Stage 1 Road Safety Audit

Gort Town Centre Public Realm Scheme

On behalf of **Galway County Council**

1.1. This report describes a Stage 1 Road Safety Audit carried out on behalf of Galway County Council on proposed alterations to the public space and carriageways within Gort Town Centre.

PARKING ALLOCATION PLAN

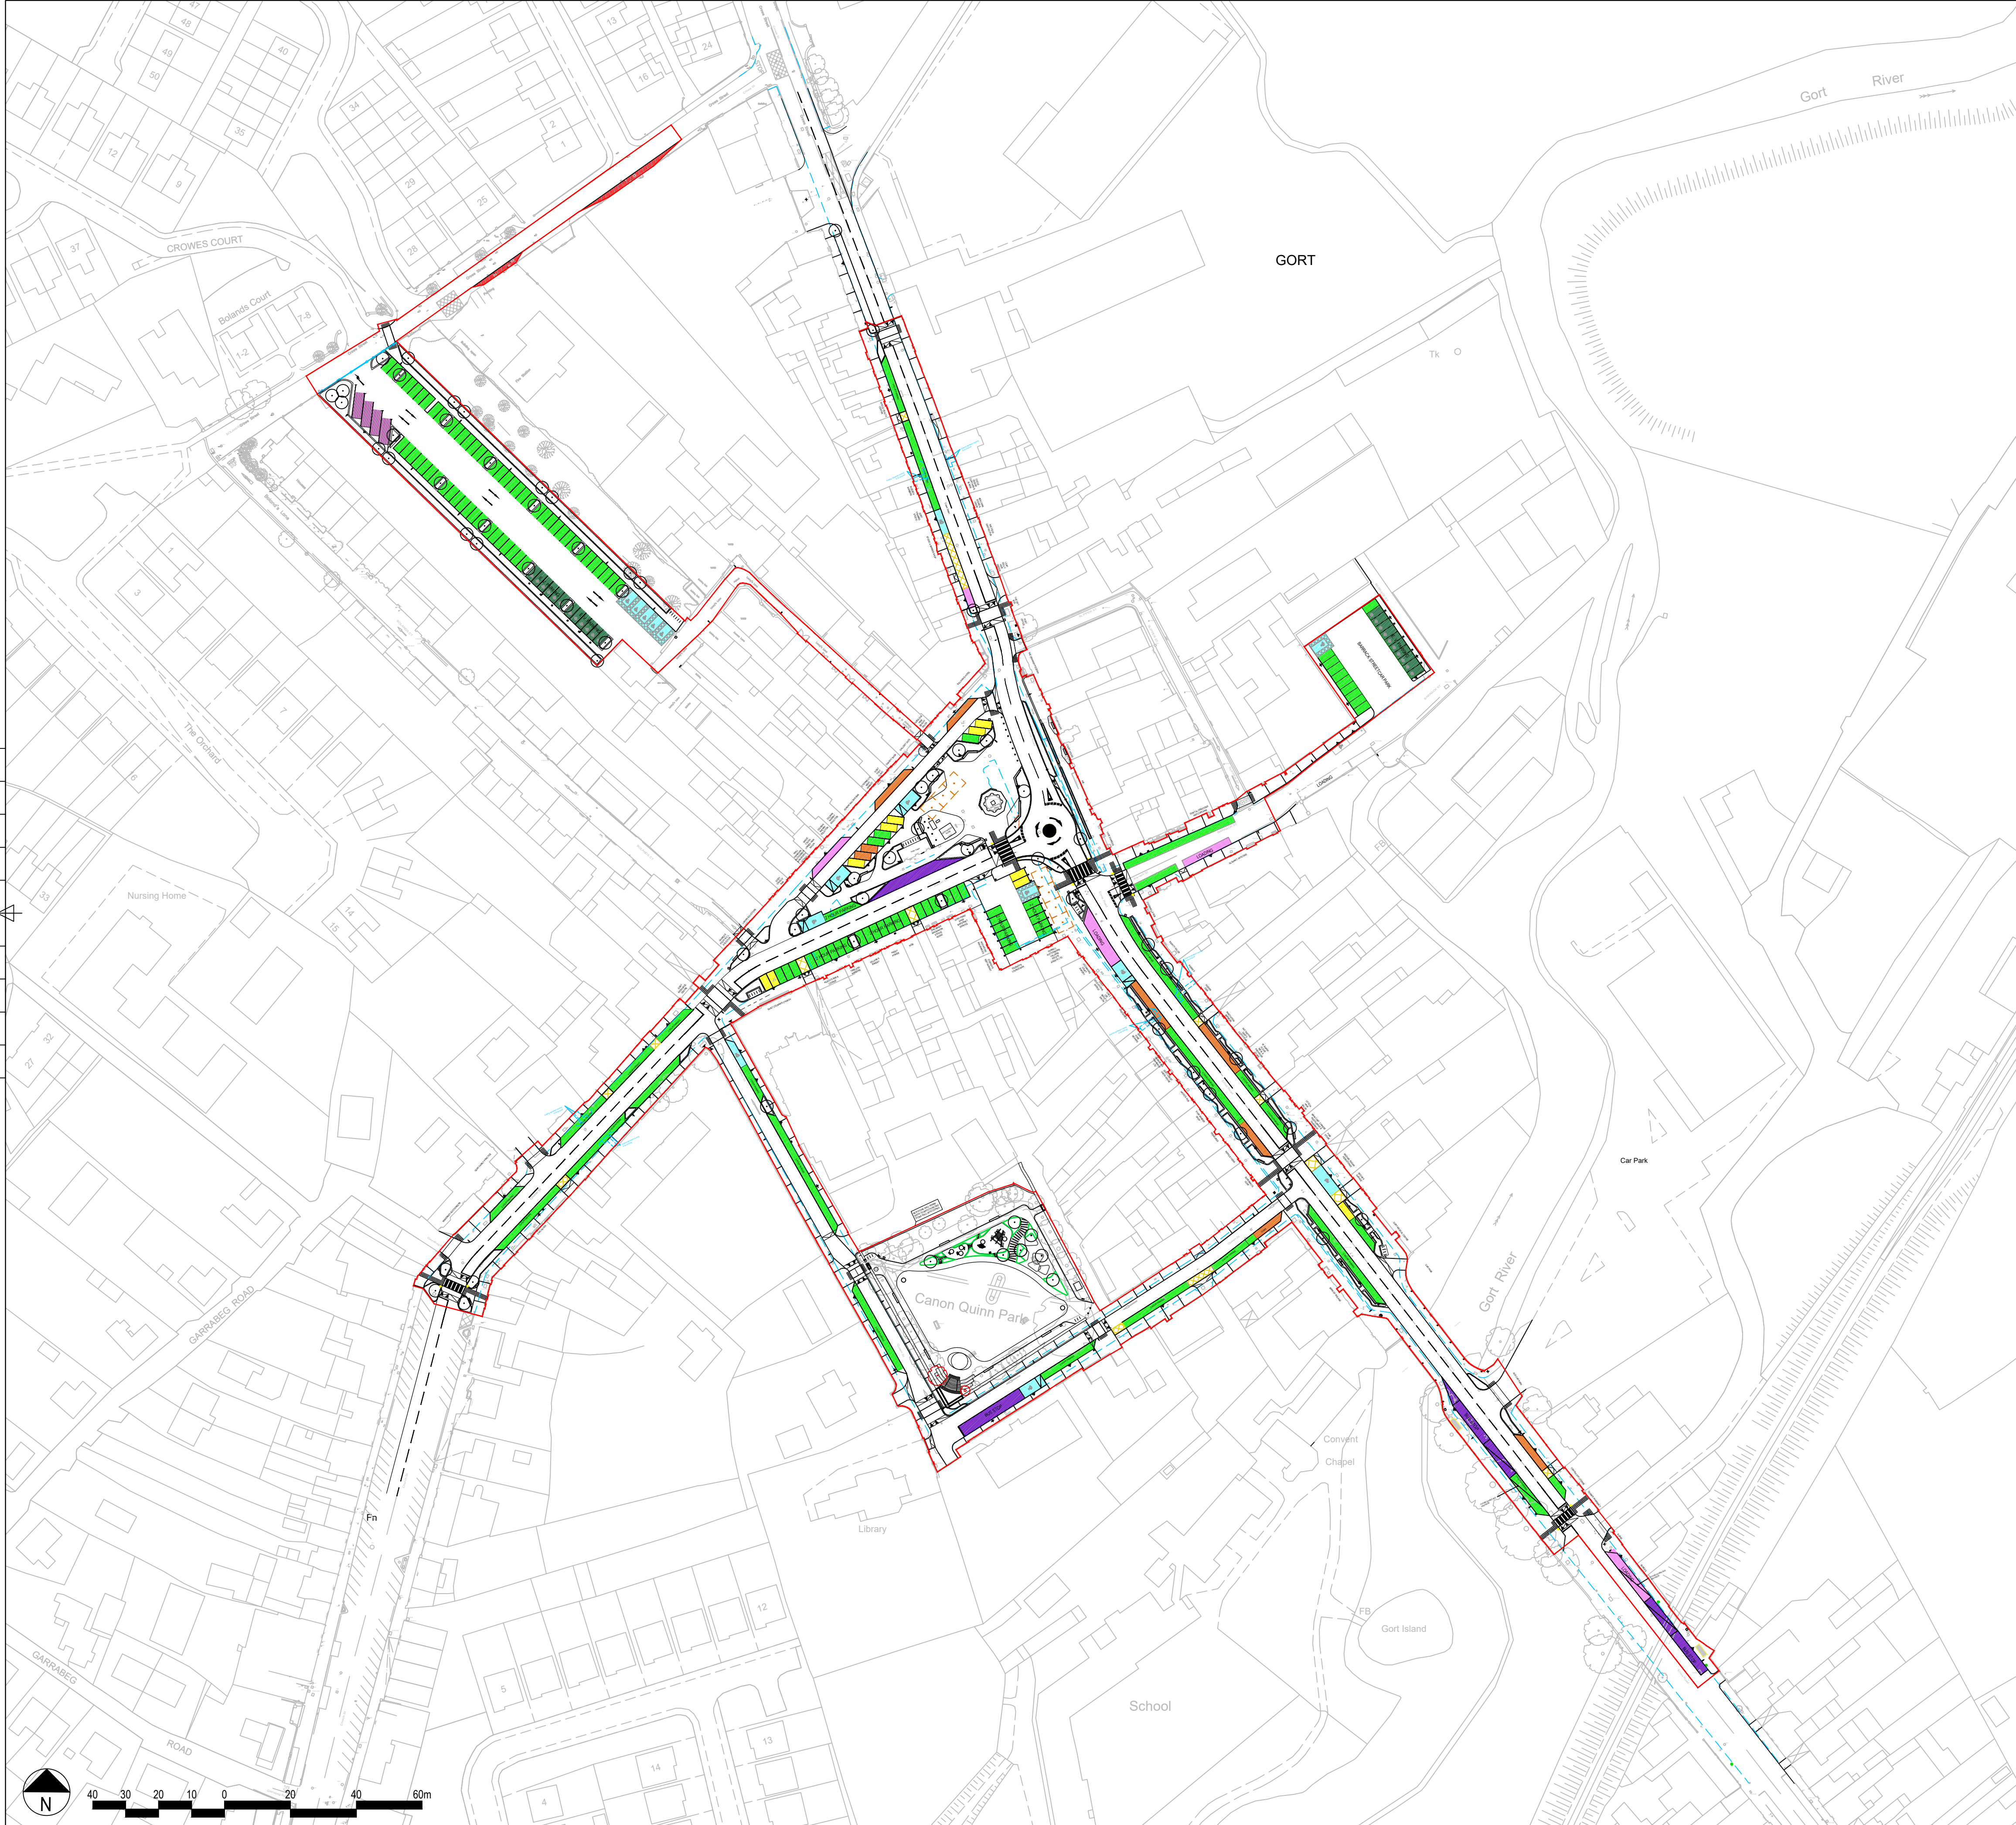
Problem: There is a long run of perpendicular car parking proposed on the Market Street main square. When these spaces are unoccupied the street will appear very wide. Wide and straight streets have a poor record of high vehicle speeds.

Hazard: Motorists may impact with other road users, possibly cyclists, at high-speed resulting in serious injuries.

Recommendation: Provide additional breaks in the parking that contain vertical features, in an attempt to control vehicle speeds.

Problem: There is a long run of perpendicular parking bays on Church Street. Users attempting to exit these bays may have visibility to oncoming traffic restricted by adjacent parked high-sided vehicles.

Hazard: Exiting motorists may be struck by passing mainline traffic.

Recommendation: The Design Team should provide a buffer strip between the carriageway and parking bay, such that mainline traffic can observe a moving vehicle and slow/stop to permit this vehicle safe egress.
